CVI LASER STORAGE BLDG.
MOLZEN-CORBIN & ASSOC. 1-2-88
242-5700
(L-22/D-4)

November 2, 1987

RE: CVI LASER STORAGE BUILDING
(L-22/D4)

CIVIL ASER STORAGE BUILDING

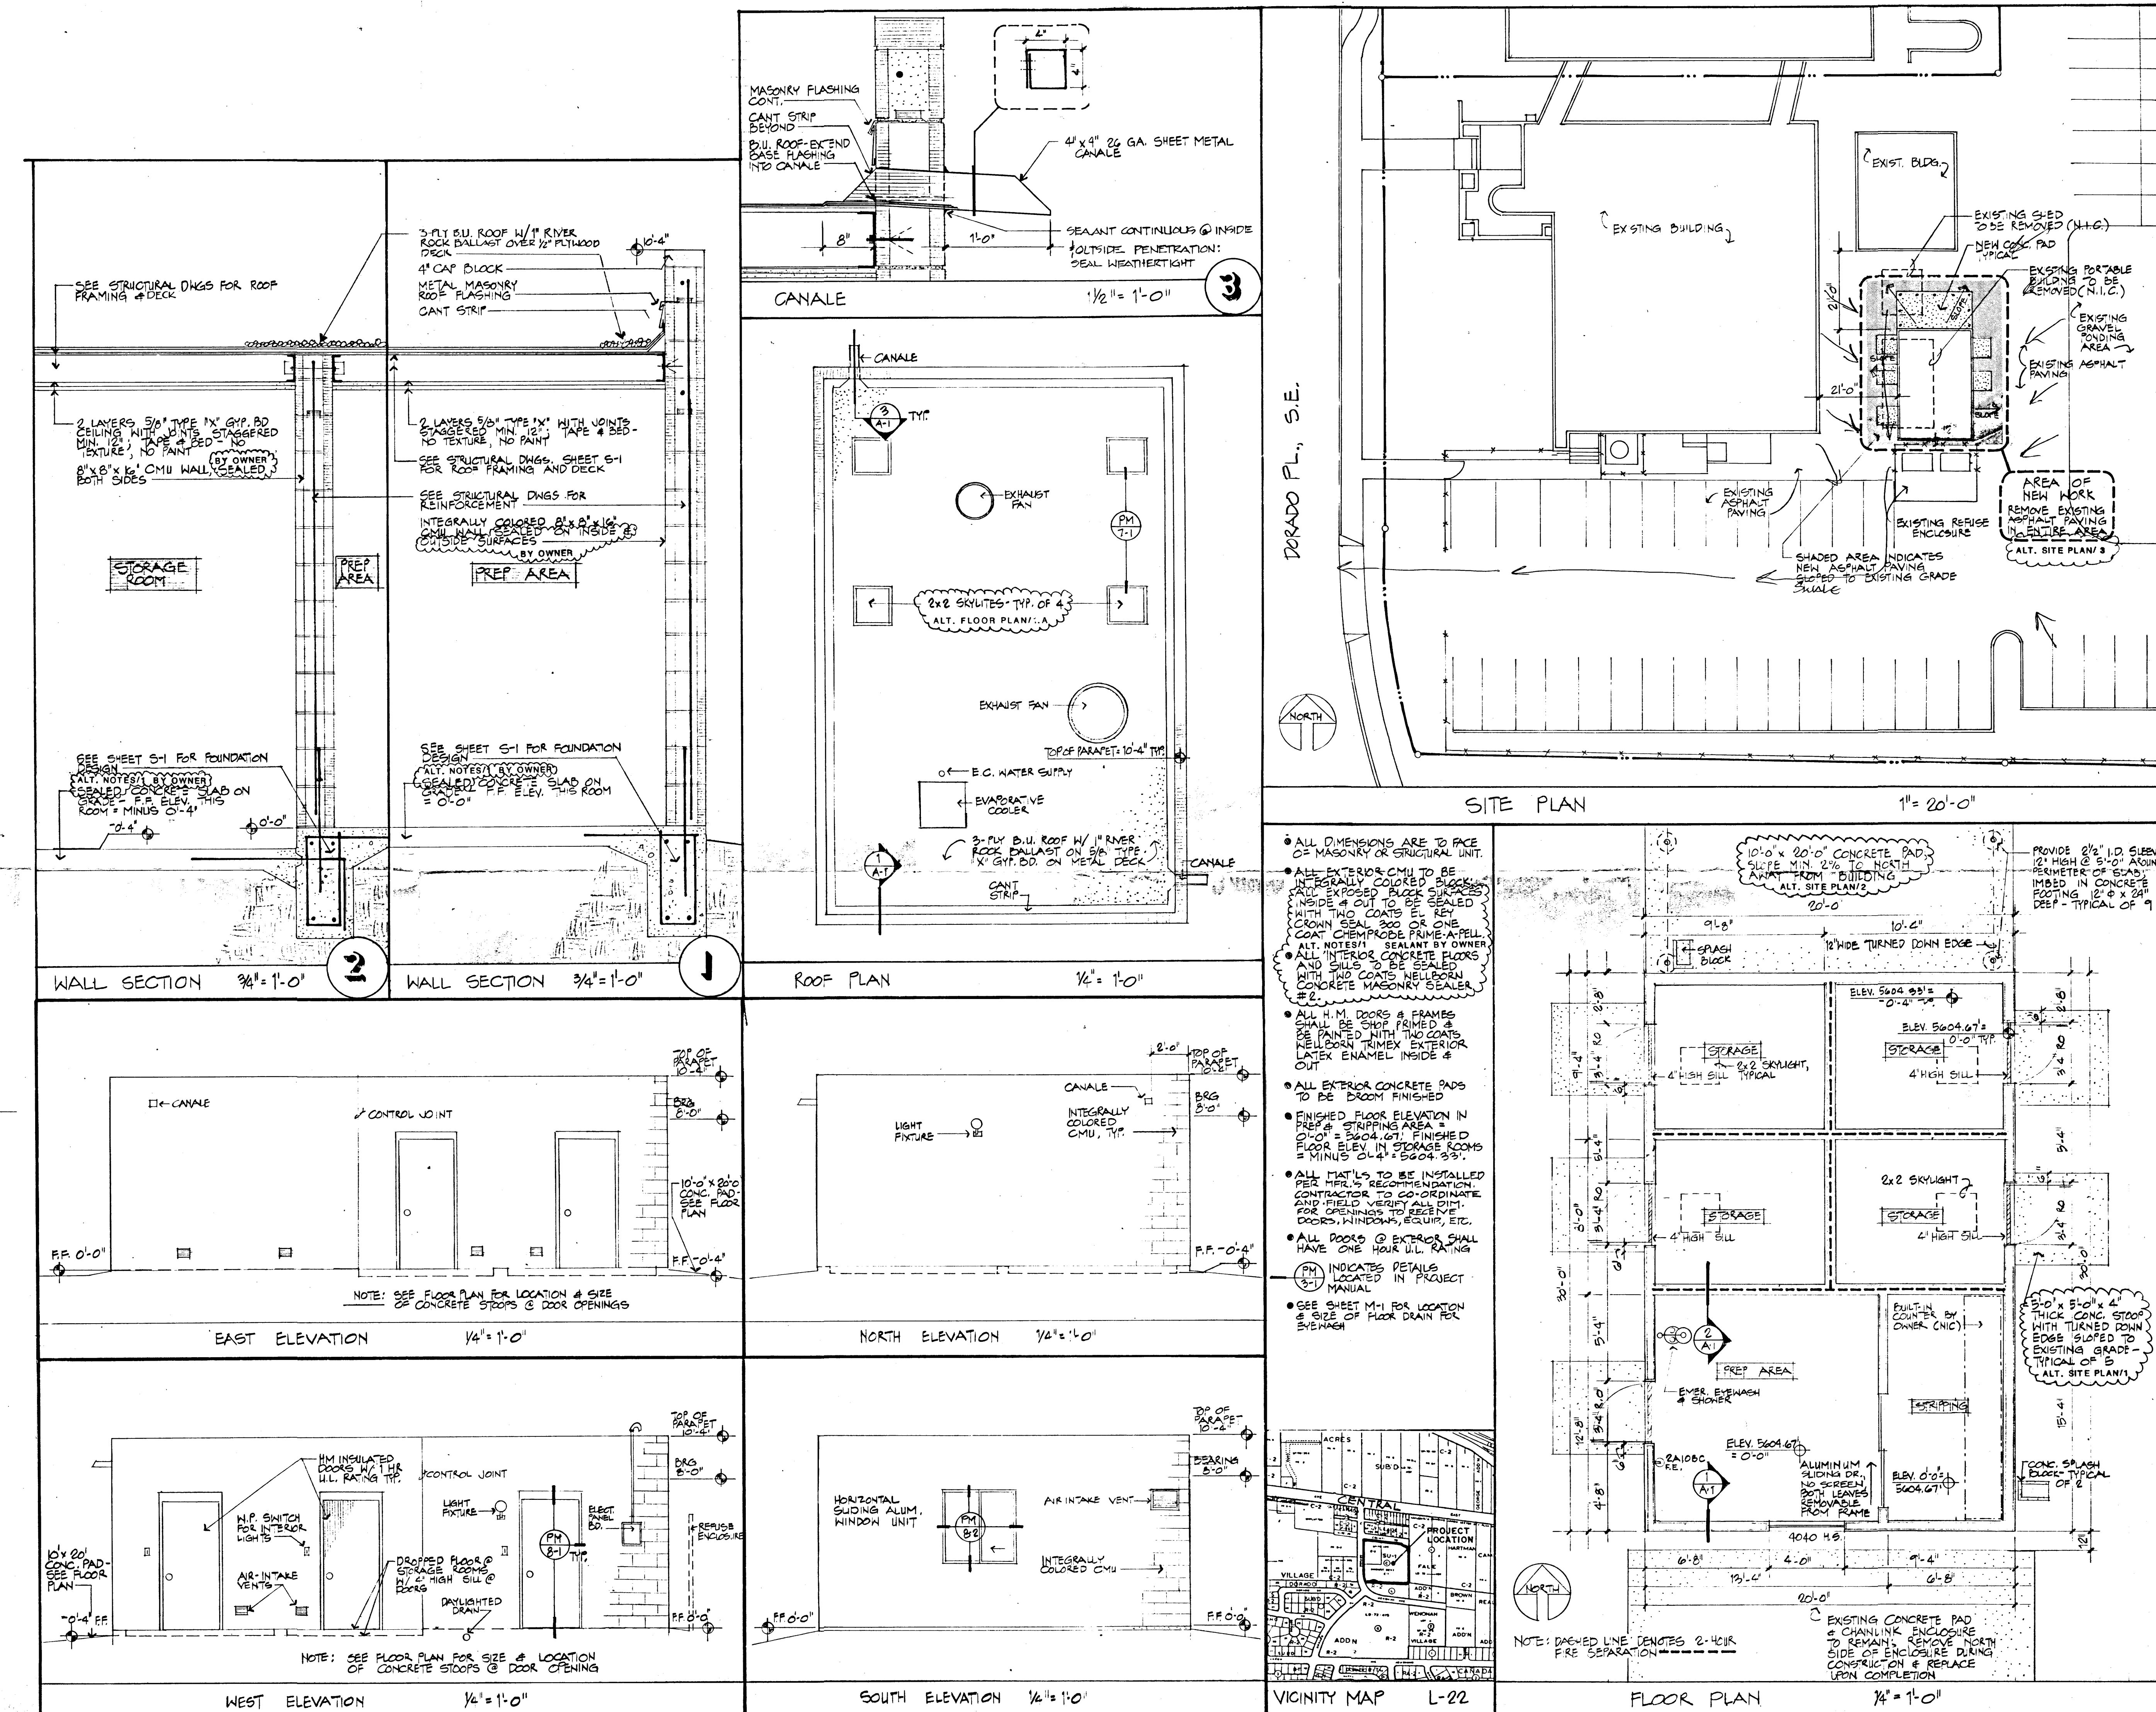
Our survey of the site has convinced me that the site is in substantial compliance with the drainage plan on file. The only apparent problem is that there is an existing paved swale ditch which will be covered up by the new paving and the new building. Your site plan does not make it obvious to the contractor that he will have to deal with a drainageway which he must not block.

If you will revise your drawing to insure that the contractor understands the drainage of the area and his responsibilities, we will be satisfied. Copies of the revised drawing must be attached to the City Building Plans on file with Code, and sent to the contractor and to us for our file. I have taken the liberty of marking a copy of your present submittal as a sample of what I had in mind.
